MECKLENBURG COUNTY
Land Use & Environmental Services Agency

MEMORANDUM

To: Charlotte-Mecklenburg Planning Commission
From: LUESA, Mecklenburg County
Date: 7.28.23
Subject: Rezoning Petition Comments

2023-029: MAGLC, LLC - Site Plan Amendment Request

**SCHEMATIC
SITE PLAN**

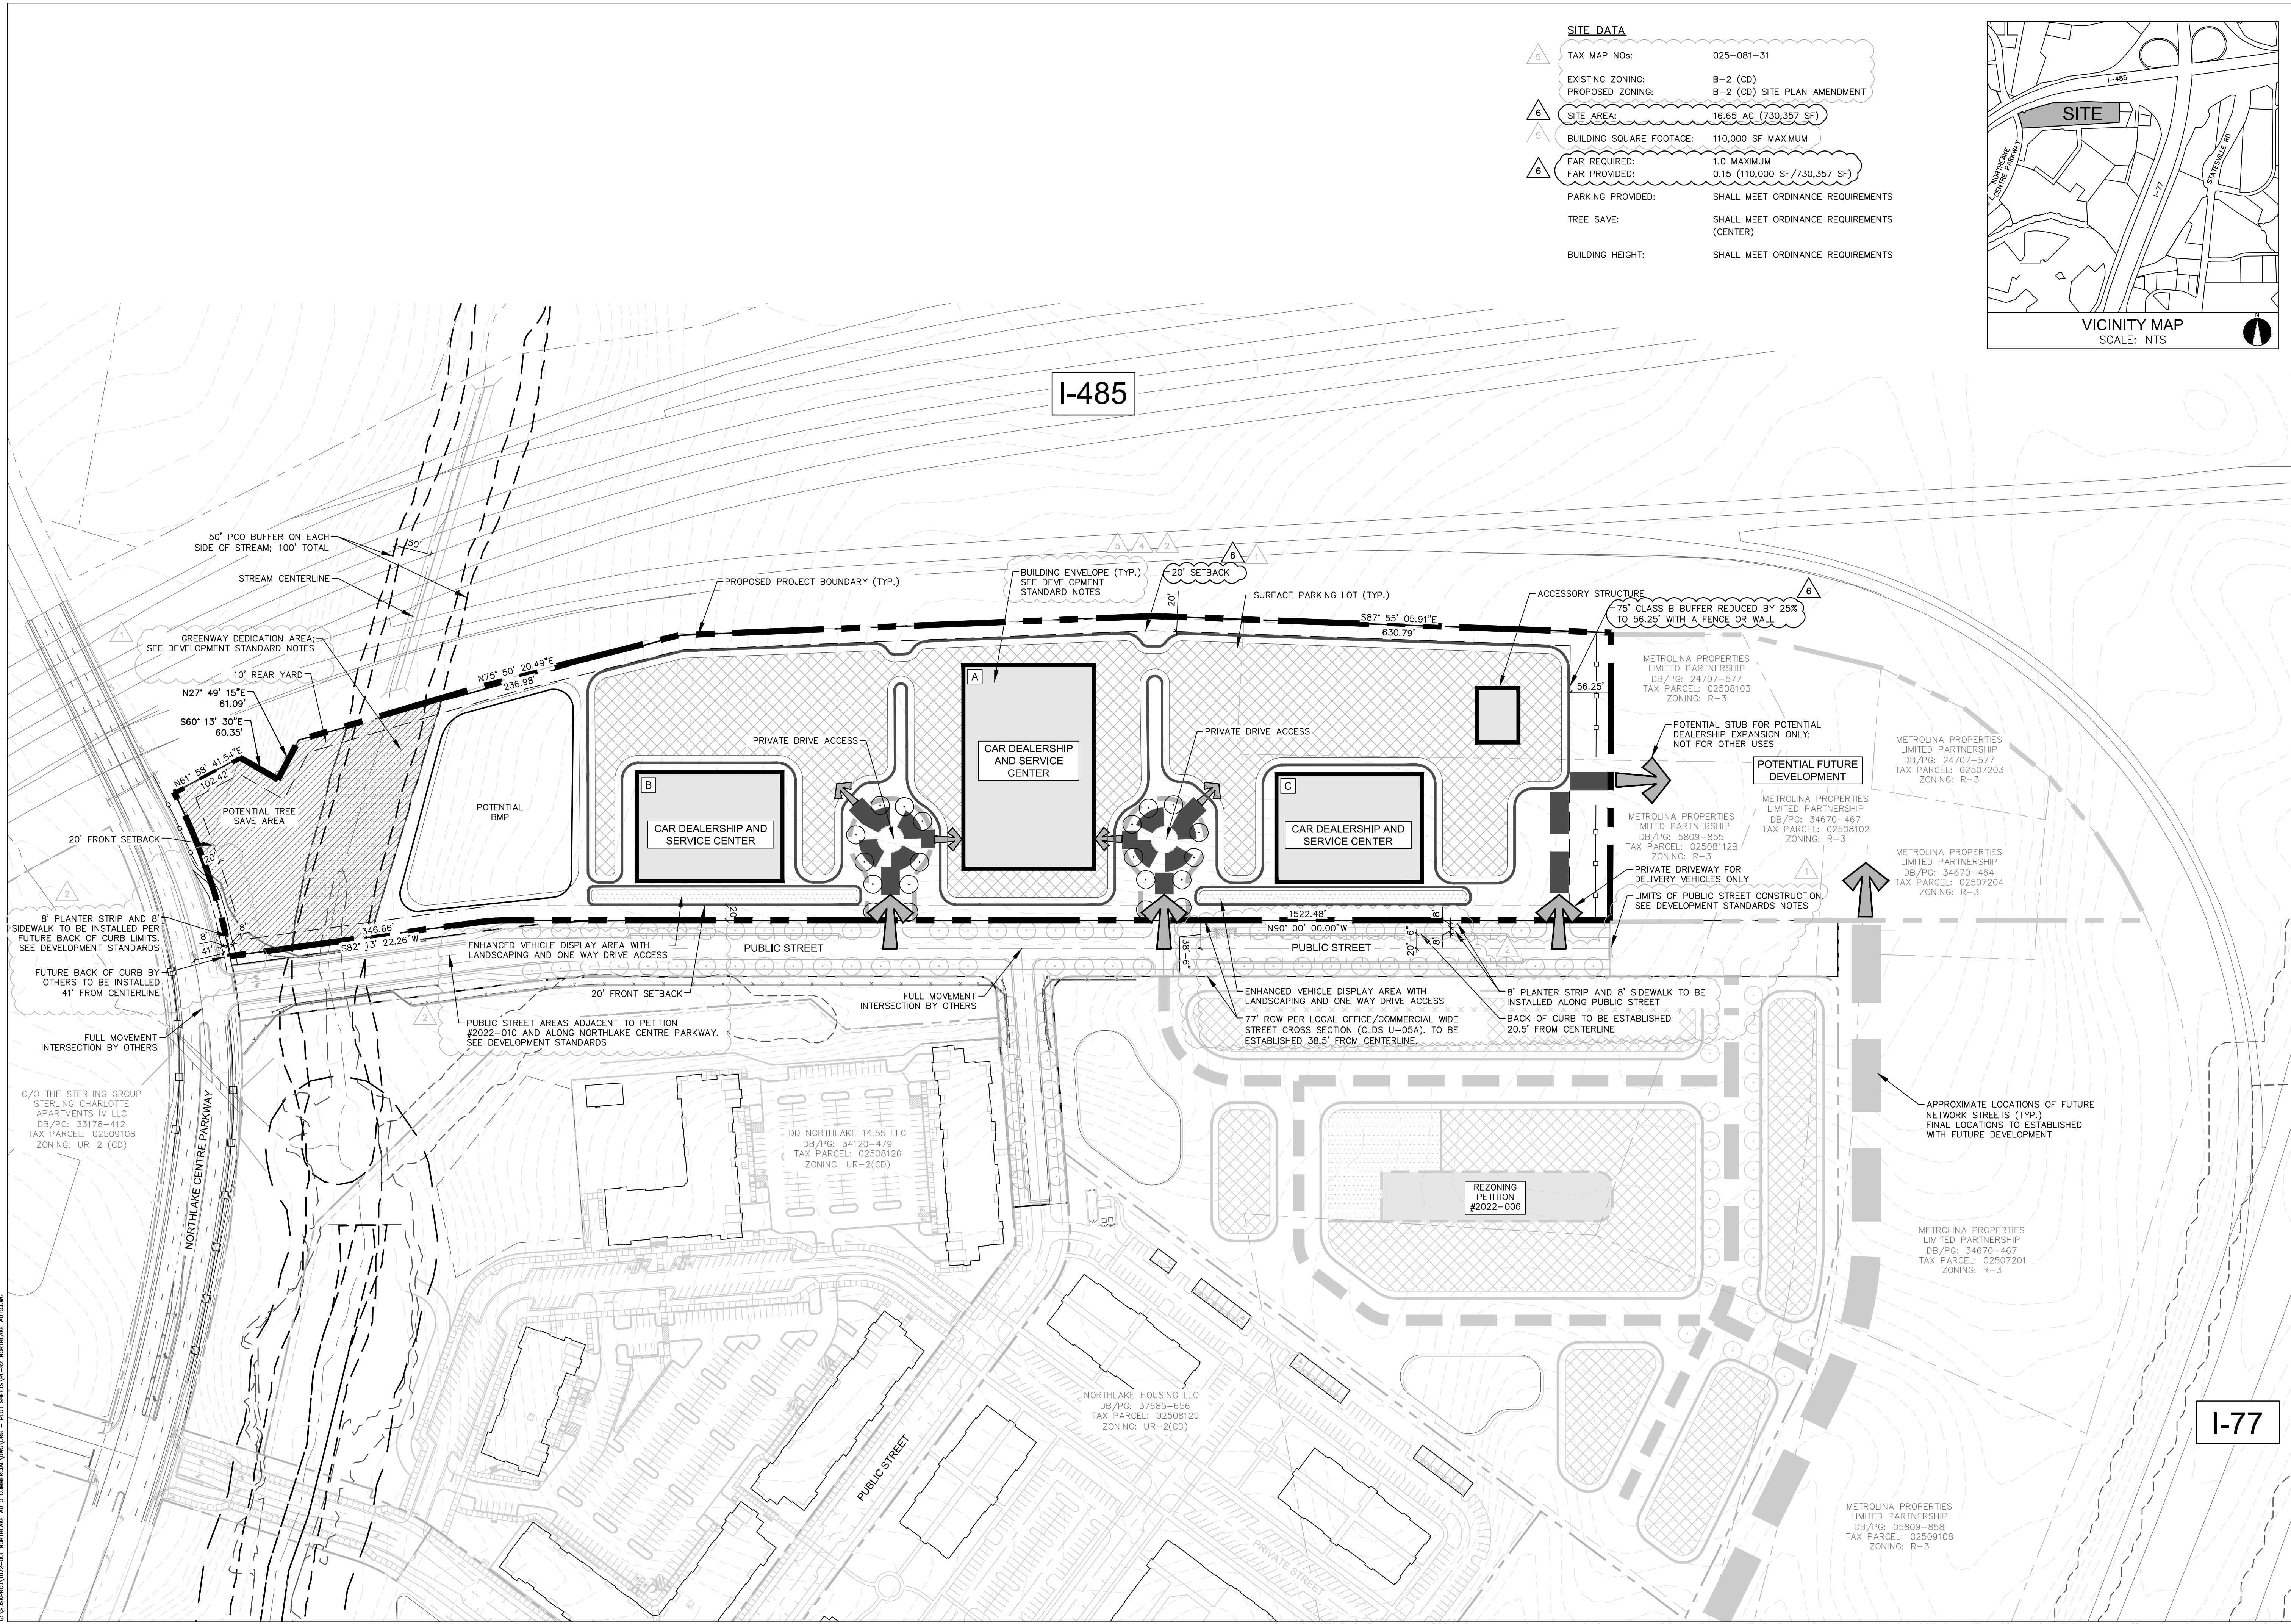
Storm Water Services Comments: "A Floodplain Development Permit from the City of Charlotte is required for all proposed construction within the regulated floodplain. There are specific building requirements for any proposed structure located within the regulated floodplain. See City of Charlotte Unified Development Ordinance Article 27 for details."
